Our ref: 100148-PEF-ZZ-XX-RP-YE-000400
Planning Ref: BN/11/22/OUT
EA Ref: HA/2022/123981/01-L01

05th October 2022

BARNHAM EASTERGATE WESTERGATE – RESPONSE TO ENVIRONMENT AGENCY’S HOLDING OBJECTION IN RELATION TO FLOOD RISK ISSUES

Drawing Title
**INITIAL BRIDGE OPTIONS
MULTI SPAN**

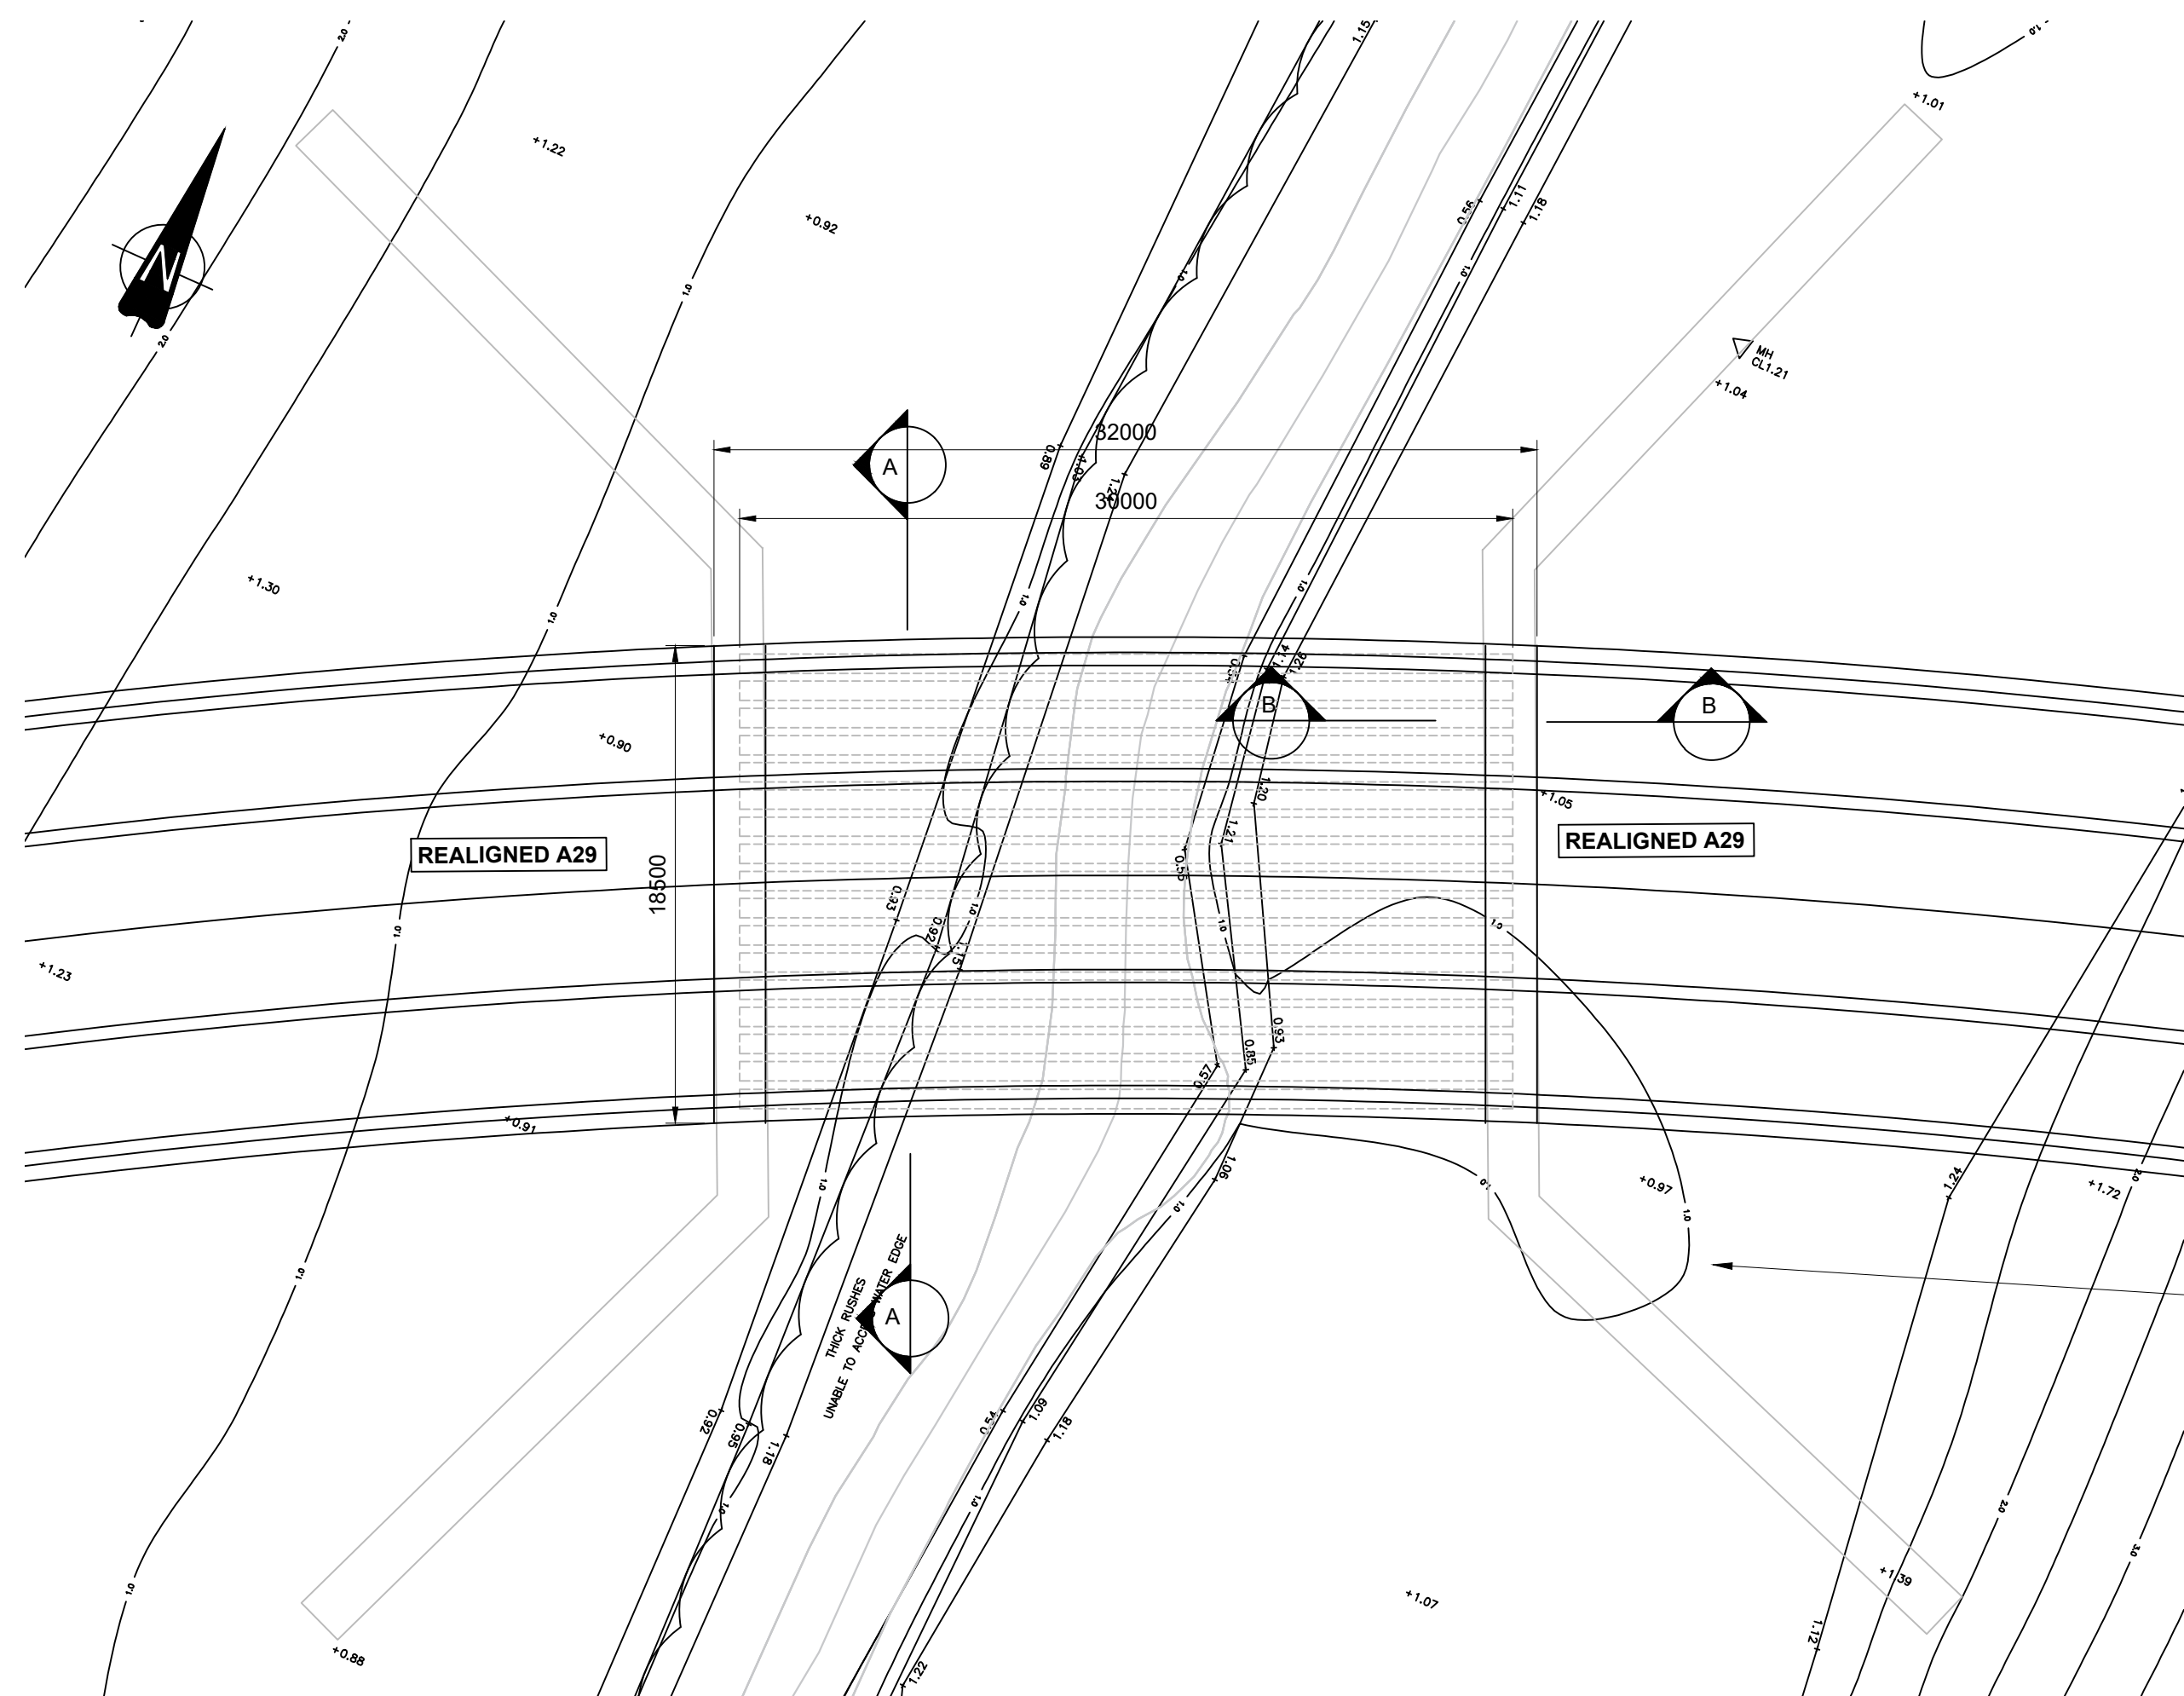
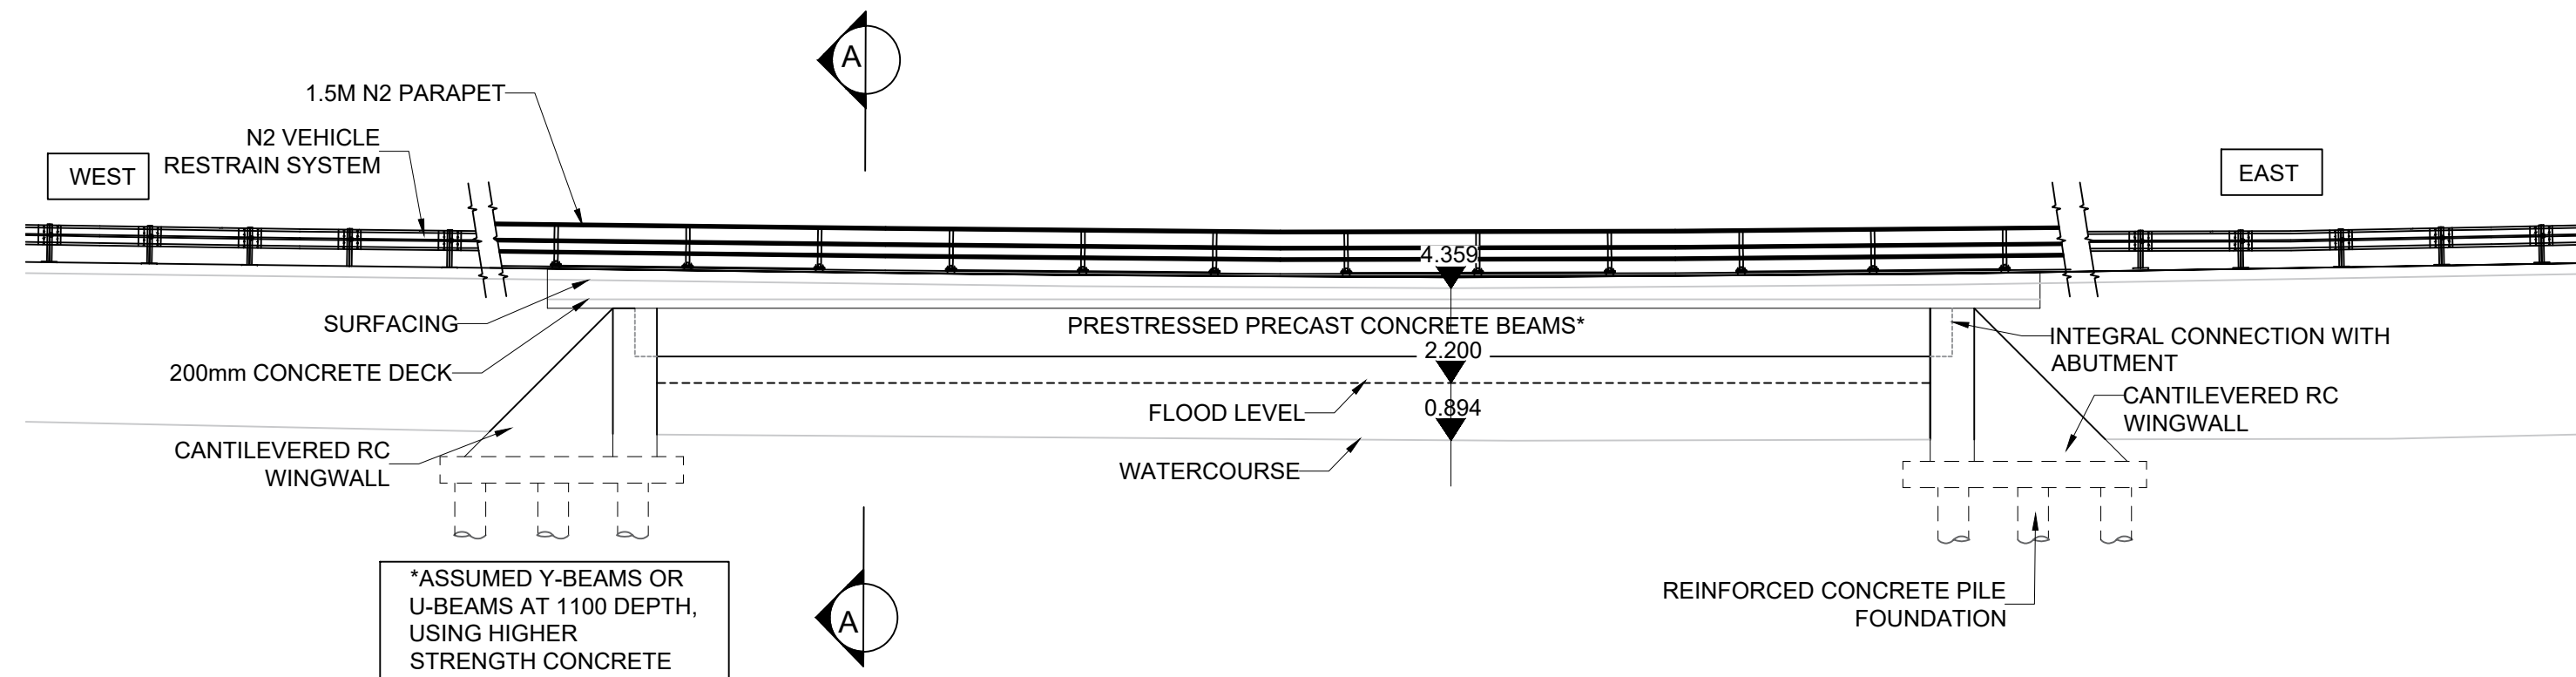
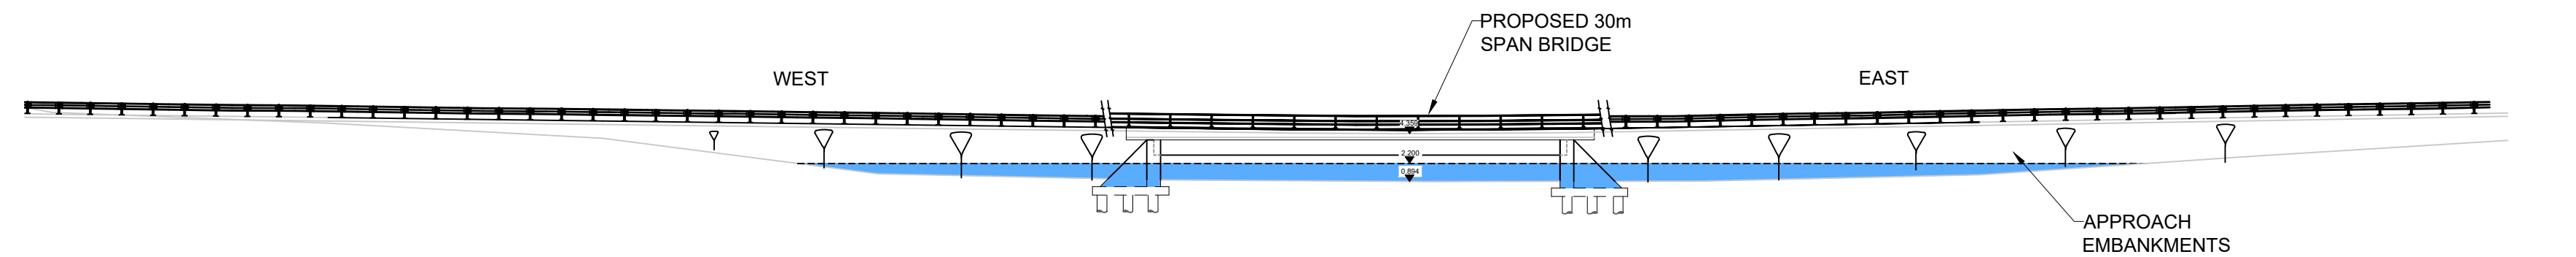
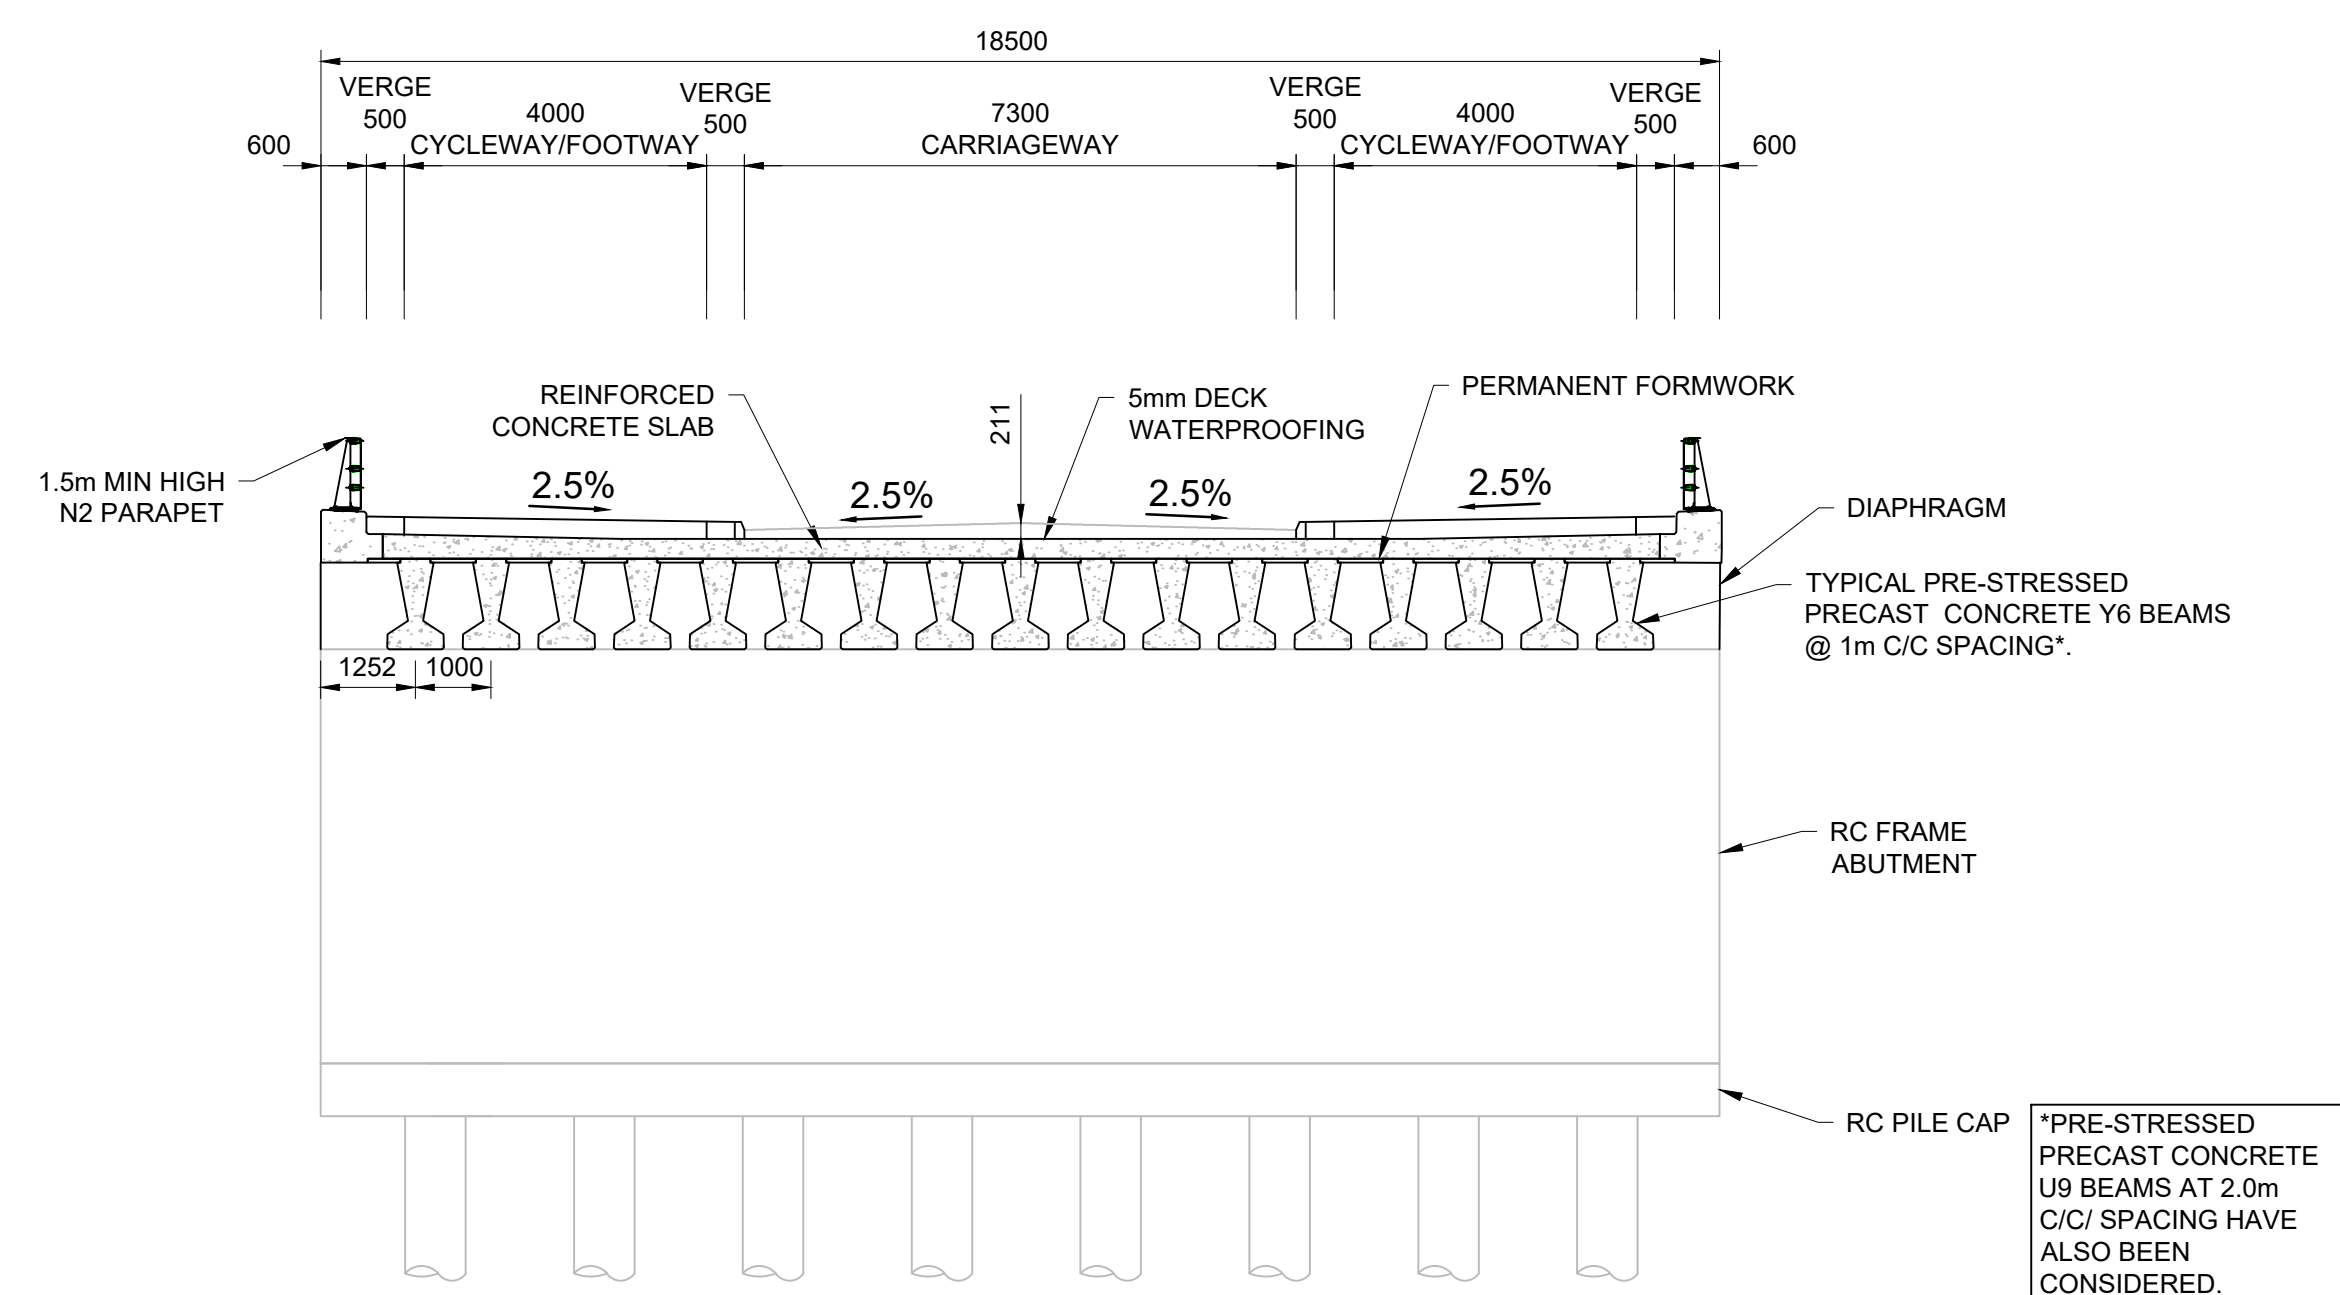
The EA’s response states that “...we would need to see reference to the latest Climate Change allowances...and their potential impact on the 200m multi-span Lidsey Rife Bridge option at multiple points.”

The 'A29 Realignment – Lidsey Rife Bridge Options' Technical Note (document ref: 13394-PEF-XX-BR-RP-S-000002) prepared by Pell Frischmann outlines an option of a multi-span bridge in section

4.1.3. An option for a multi-span bridge to bridge the entire floodplain and defined valley of the Lidsey Rife was considered and discounted, because:

- Approximately 7 piers, plus abutments at either end of the bridge would be required and would not be perpendicular to the predominant flow direction, which can disrupt flows and increase the risk of blockage. The road alignment cannot be amended due to the design speeds of the road that requires minimum radii for curves, coupled with the constraints on the alignment as it passes over the Lidsey Rife, then heads south over the access to the treatment works and other facilities.

- Maintenance constraints in terms of accessibility for inspections and the introduction of increased points of vulnerability and degradation at expansion joints between the bridge sections.

- It increases the intrusive piling and foundation works needed to construct the additional piers, which in an area with known elevated groundwater could cause additional works in terms of dewatering of excavations and/or introduce potential pathways for surface contaminants and pollutants to enter groundwater receptors.

Overall, due to the introduction of a number of additional locations vulnerable to degradation, increased difficulty in inspection, heightened vulnerability to structural damage and anticipated cost of the structure, means this design was discounted as an unviable option.

Nevertheless, hydraulic modelling has been carried out of the design event to understand the flood risk implications of such a structure. When including the location and number of piers recommended as part of the Bridge Options report this results in a change to the 2D mesh within the hydraulic model that means direct comparison of the 2D results is inappropriate. A drawing has been prepared (A1994-PEF-ZZ-XX-SK-YE-0805) that shows spurious changes to peak water levels throughout the domain that are unlikely to be caused as a result of the bridge piers. However, comparing the in-channel levels as before shows a nominal increase in water level upstream of the structure of 0.005m (5mm) and similar changes in the order of +/-4mm downstream of the site to the embankment option.

Whilst the multi-span option with piers results in smaller changes to the peak flood depths, it is not considered a substantial enough betterment to the existing flood situation to warrant its preference over the embankment option due to the associated disadvantages of the design approach. With the piers set skewed to the preferential flow direction, the possibility of blockage and structural damage is increased and does not warrant progression of a solution that would be more susceptible to damage, and potentially be unviable from a cost perspective.
